Recommendation Report for Planning Permission

REF NO: A/3/18/PL

LOCATION: Land at Arundel Road/A27
Angmering
BN164EU

PROPOSAL: Change of use of land to storage (B8 Storage or Distribution), erection of barn & hardstanding (resubmission following A/111/17/PL).

Appendix A
Site Layout Plan

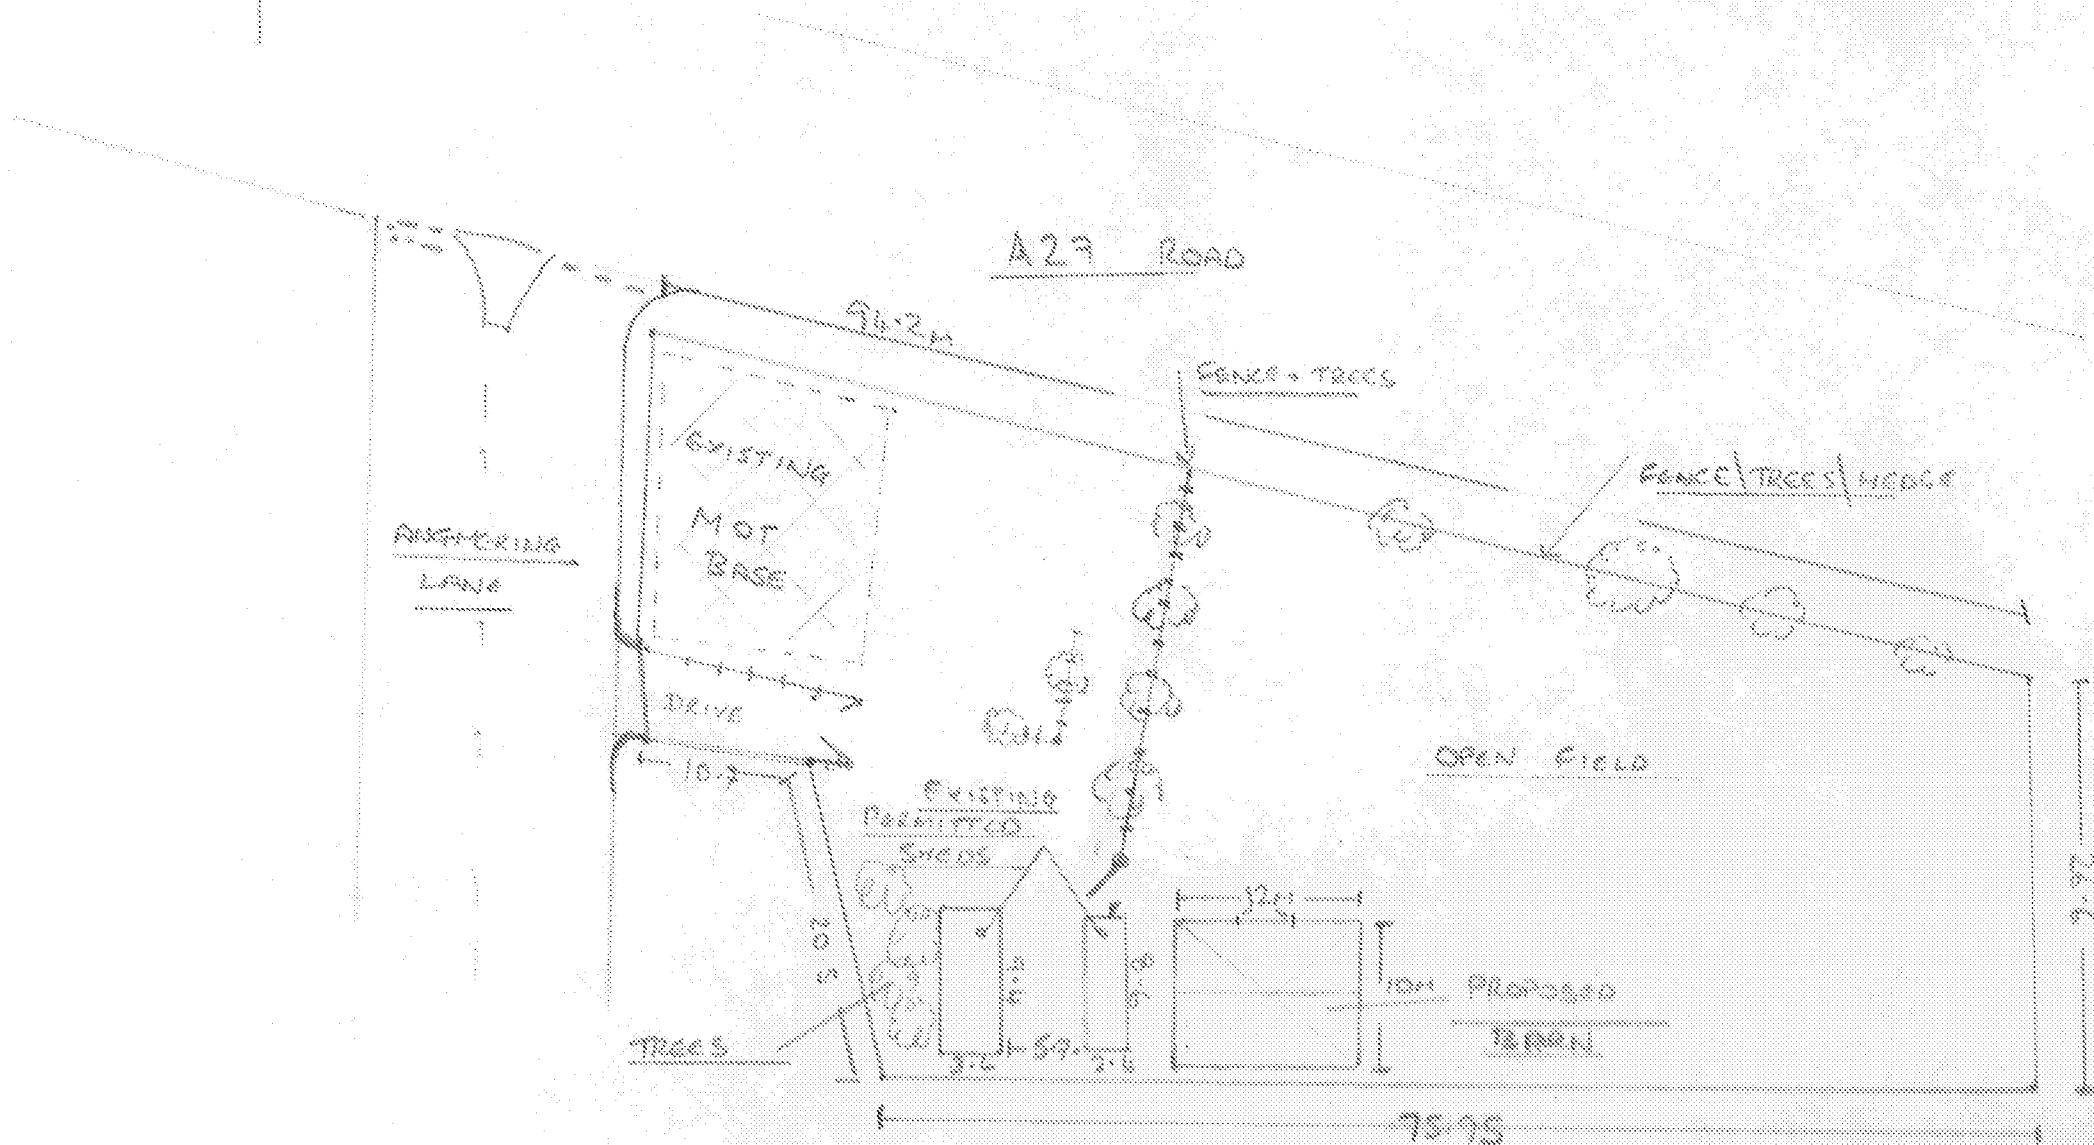
Previously on site several large trailers were observed. No evidence of ability for these to turn within the site was previously provided. The Technical Note provides swept path tracking for the turning of a car and caravan. While these plans themselves are acceptable, they do not represent the scenario of large HGV vehicles which could be associated with a B8 use class development.

Drawing:
1711056-SK01

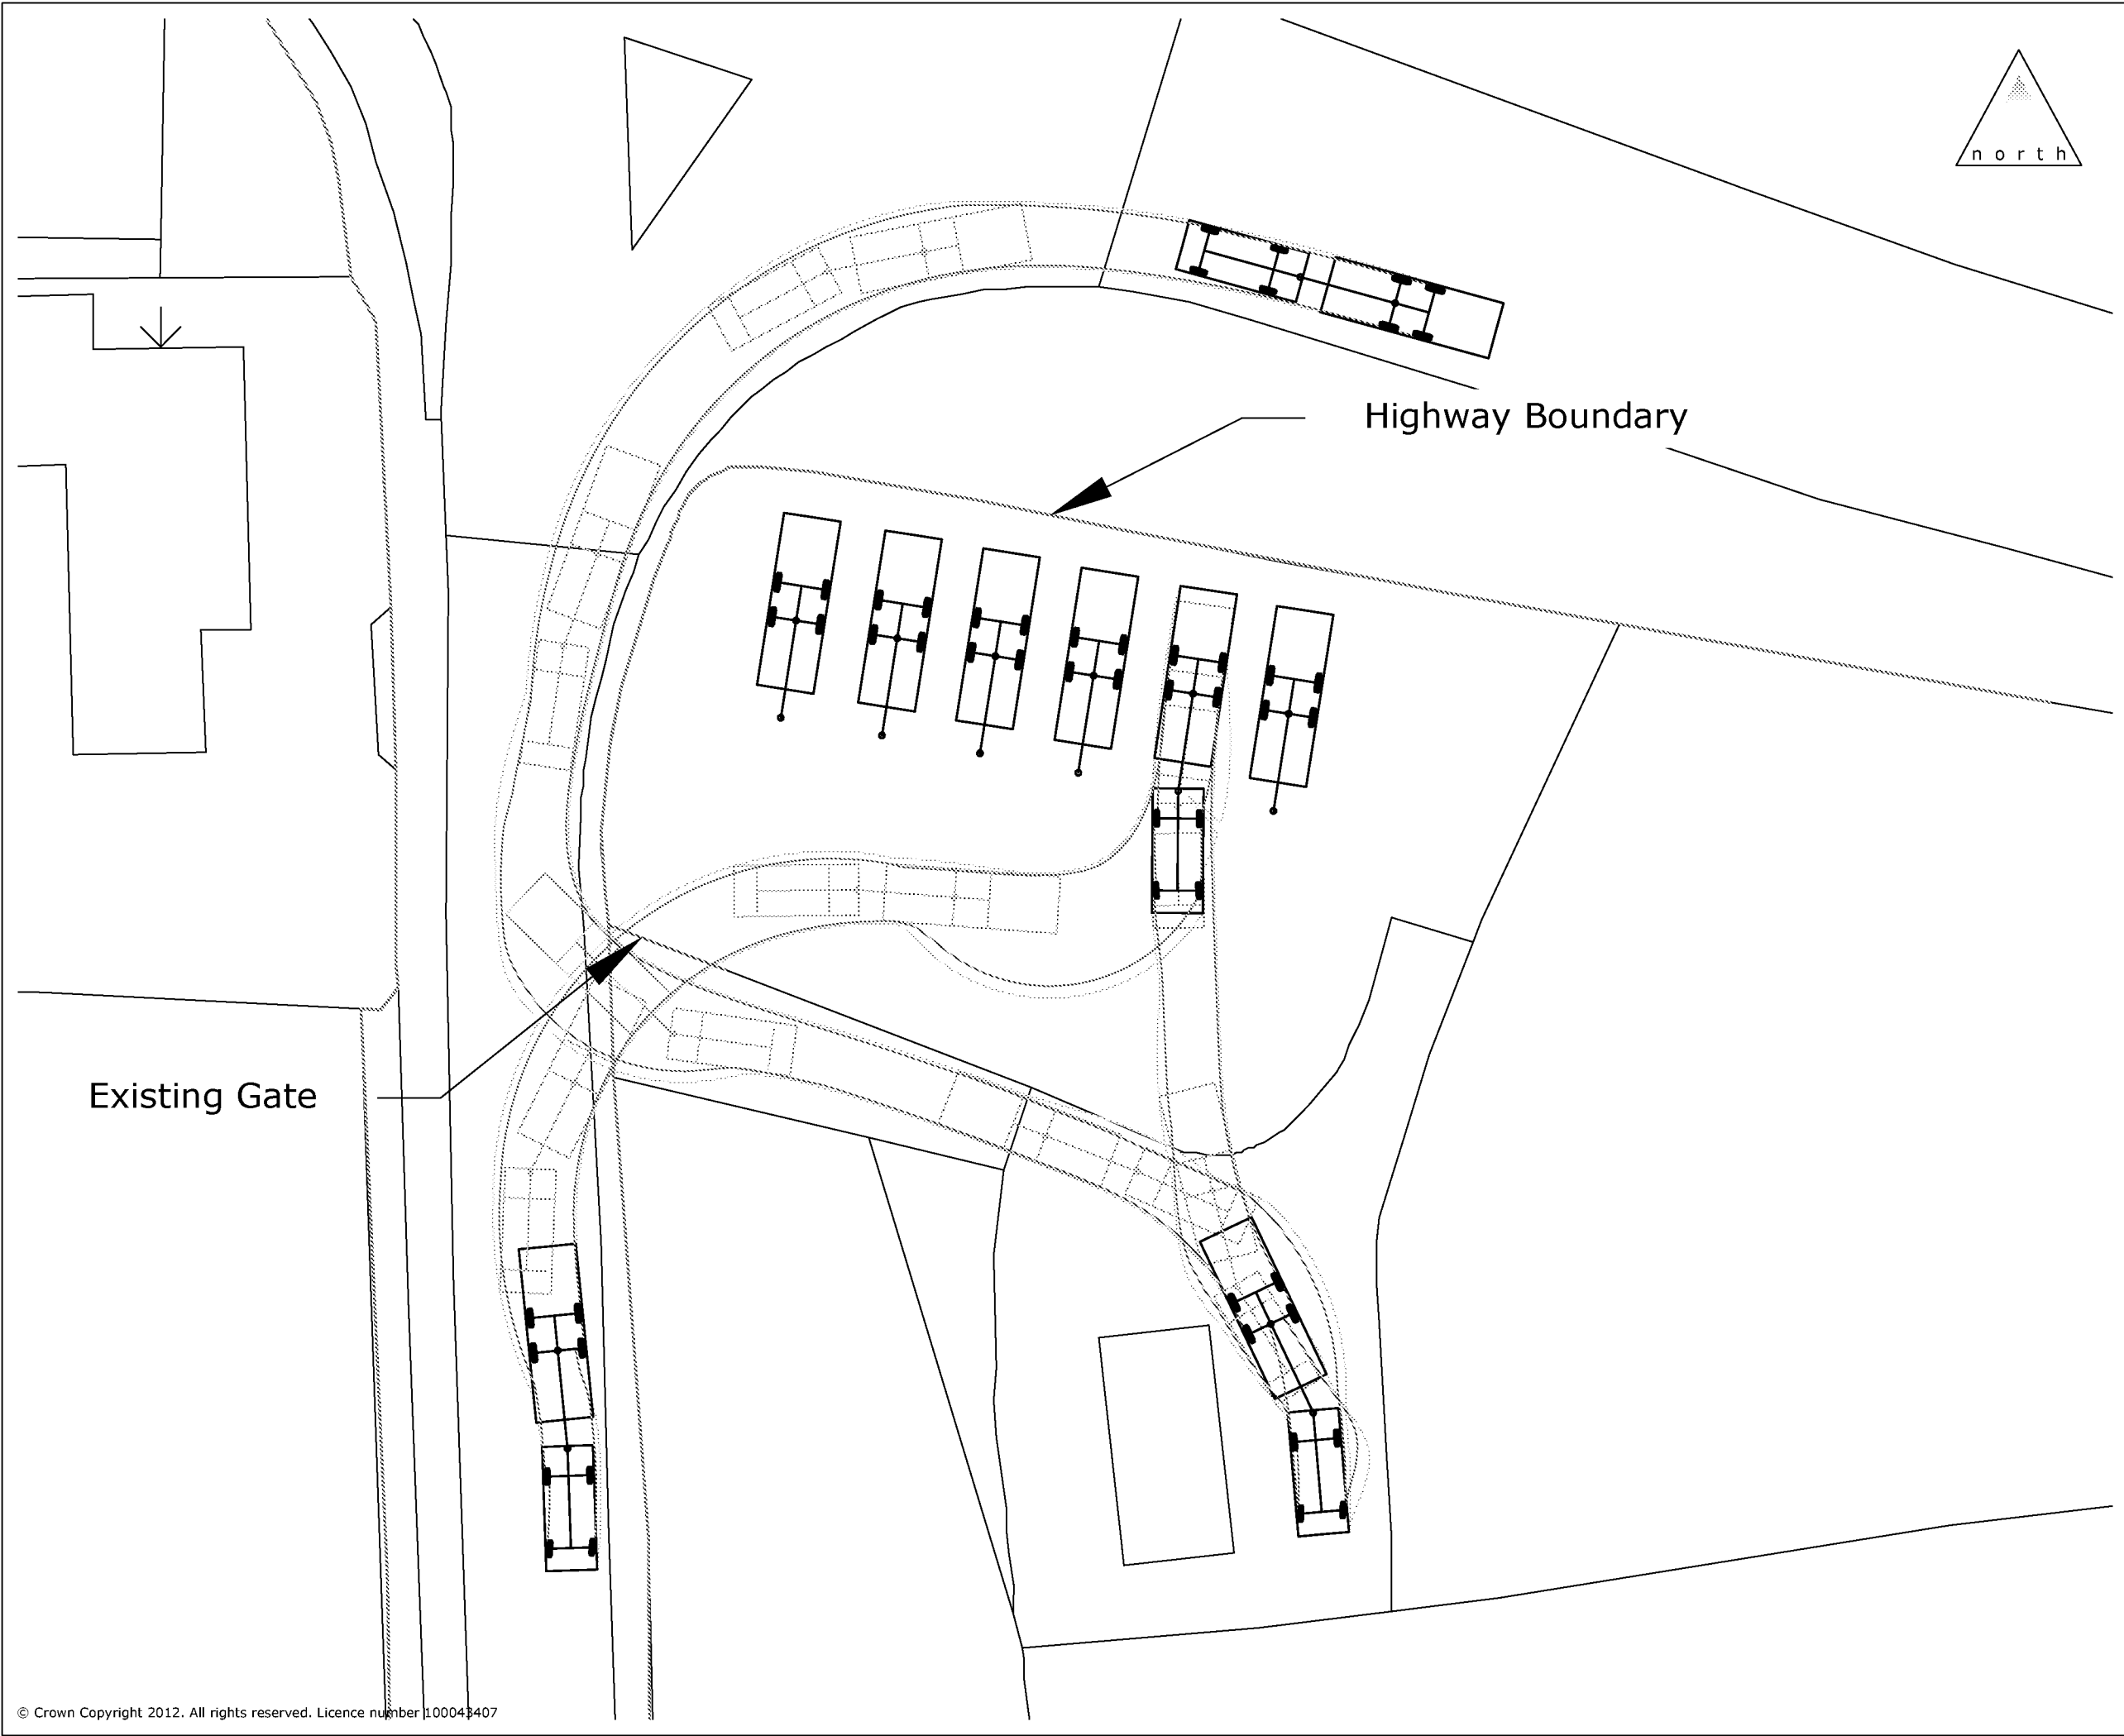
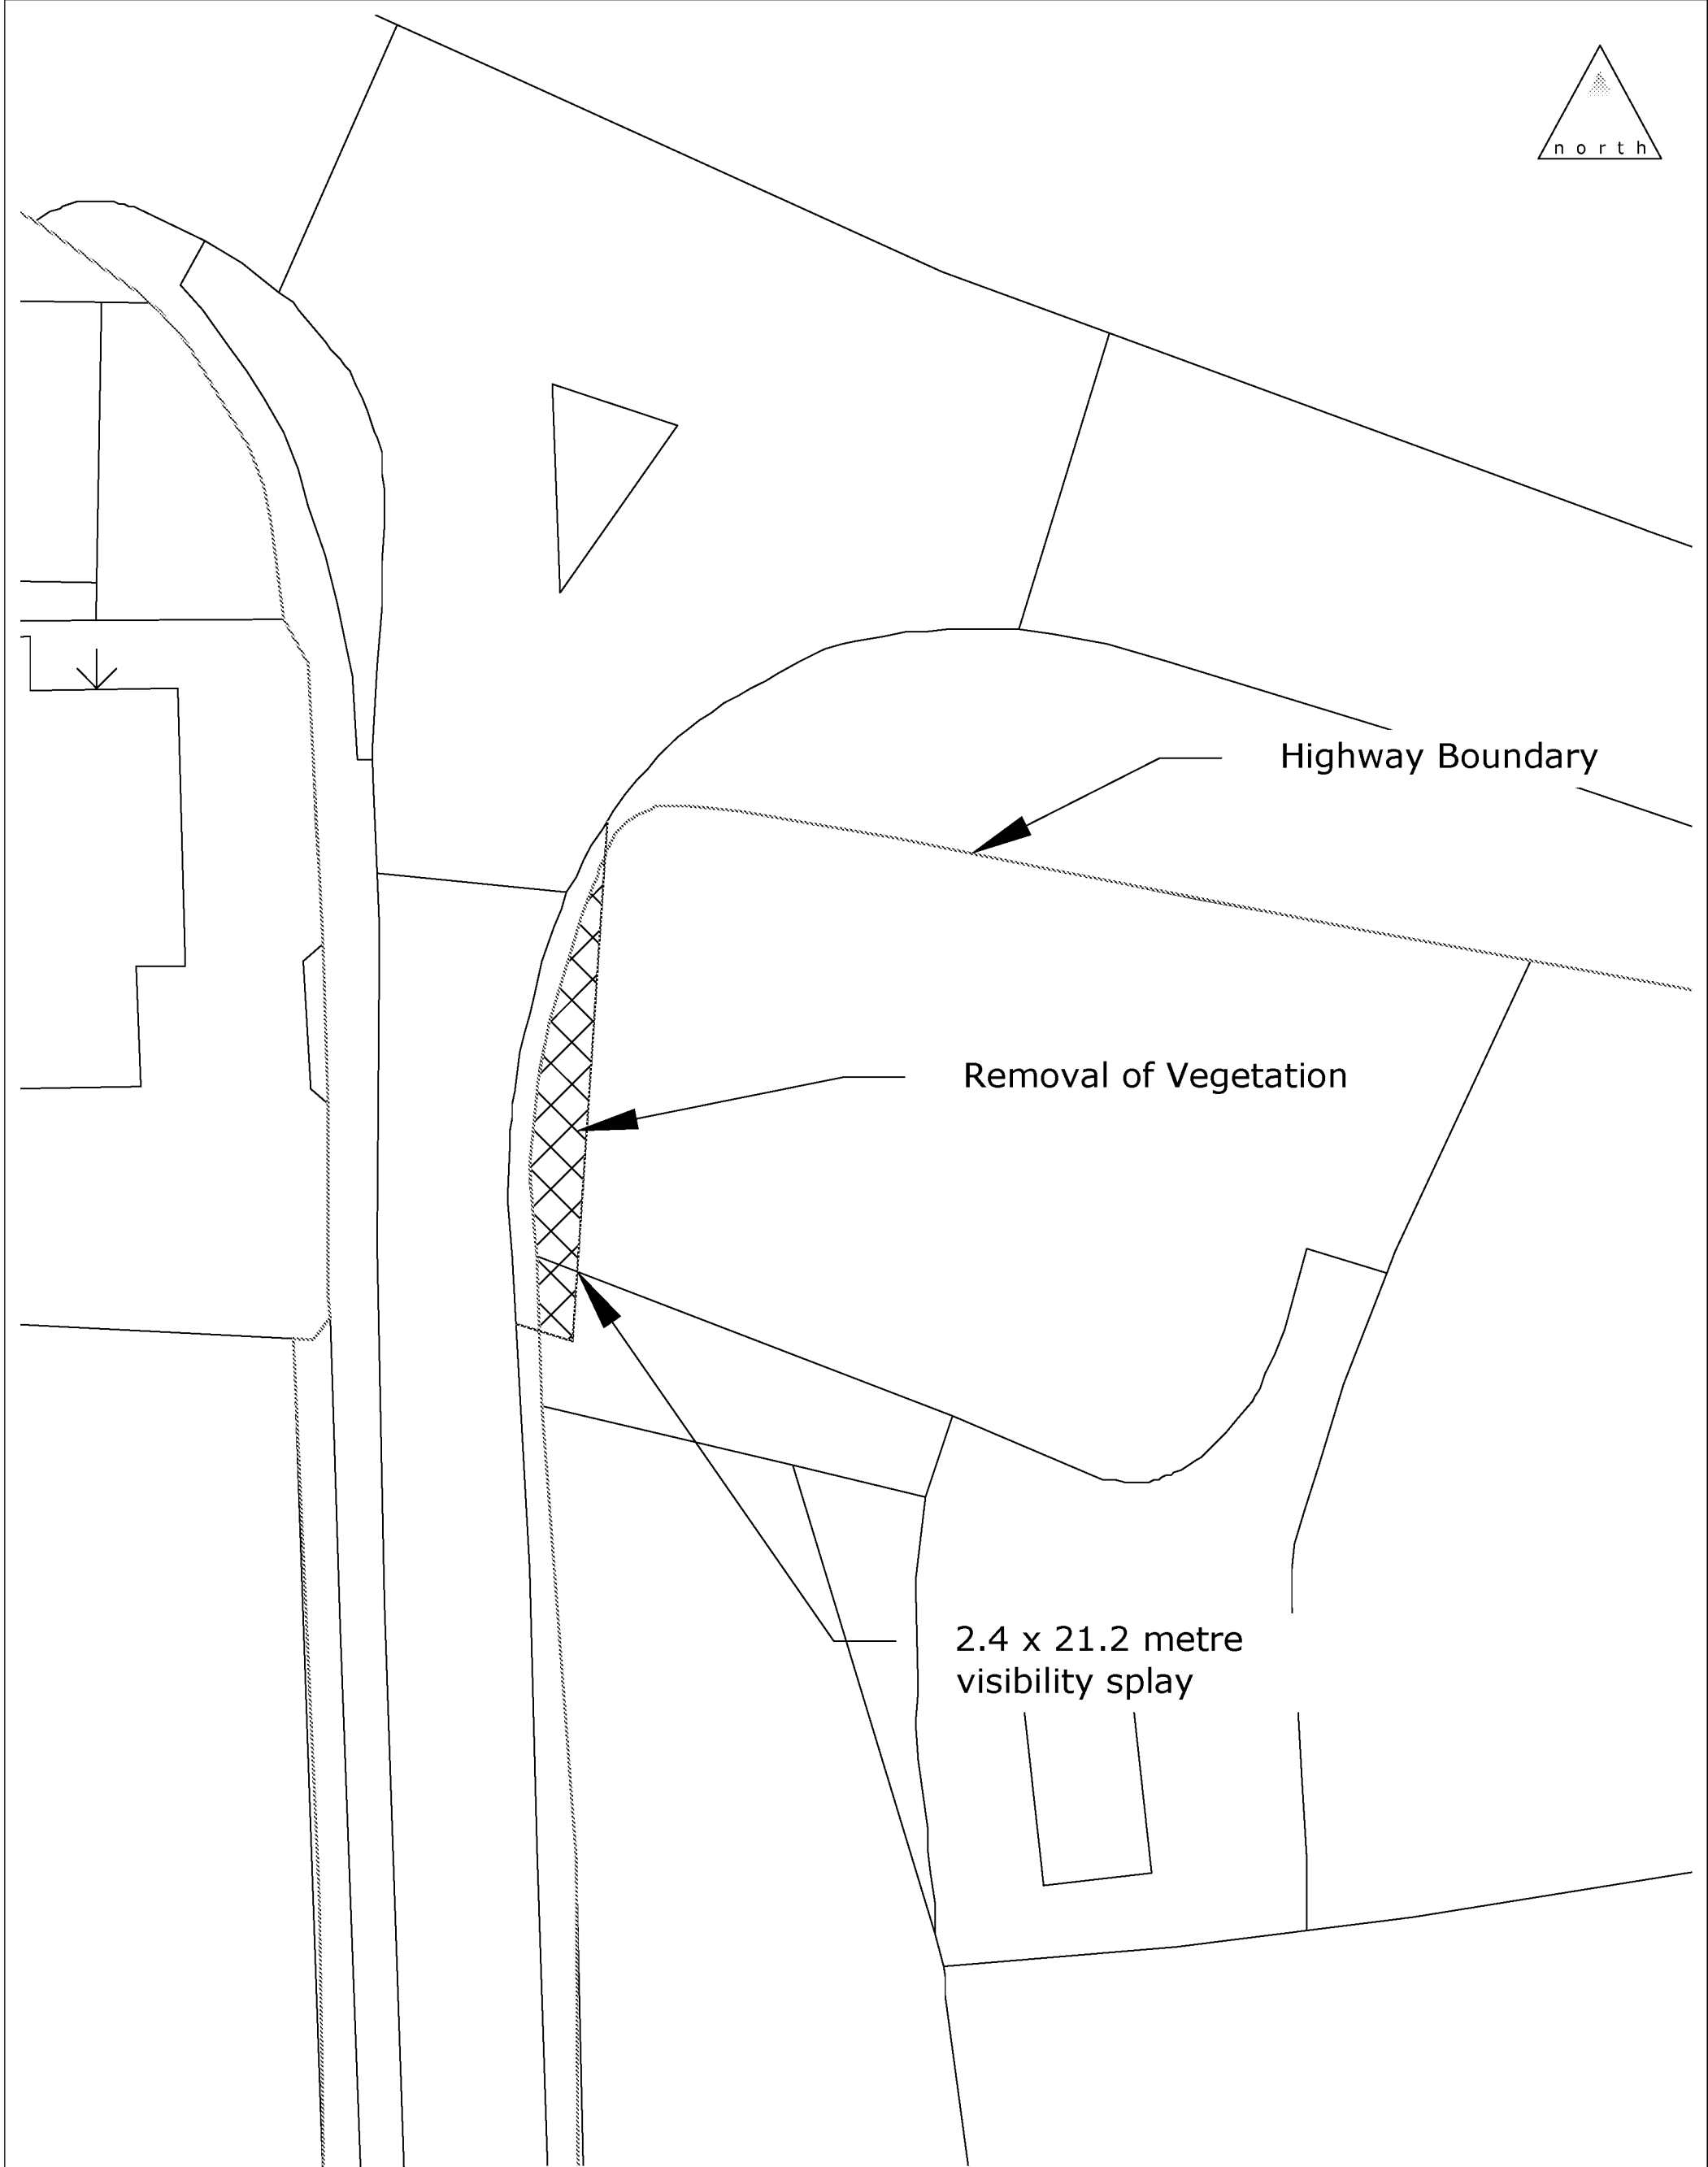
With regard to the tree, I would be minded to accept that the plan provided (1711056-SK01 Rev A) does demonstrate that that tree will not fully obstruct a vehicle within the envelope of visibility for a 21.1 metre visibility splay. I would ask this is accurately reflected in CAD if we get to the position where this is formally submitted for consideration.
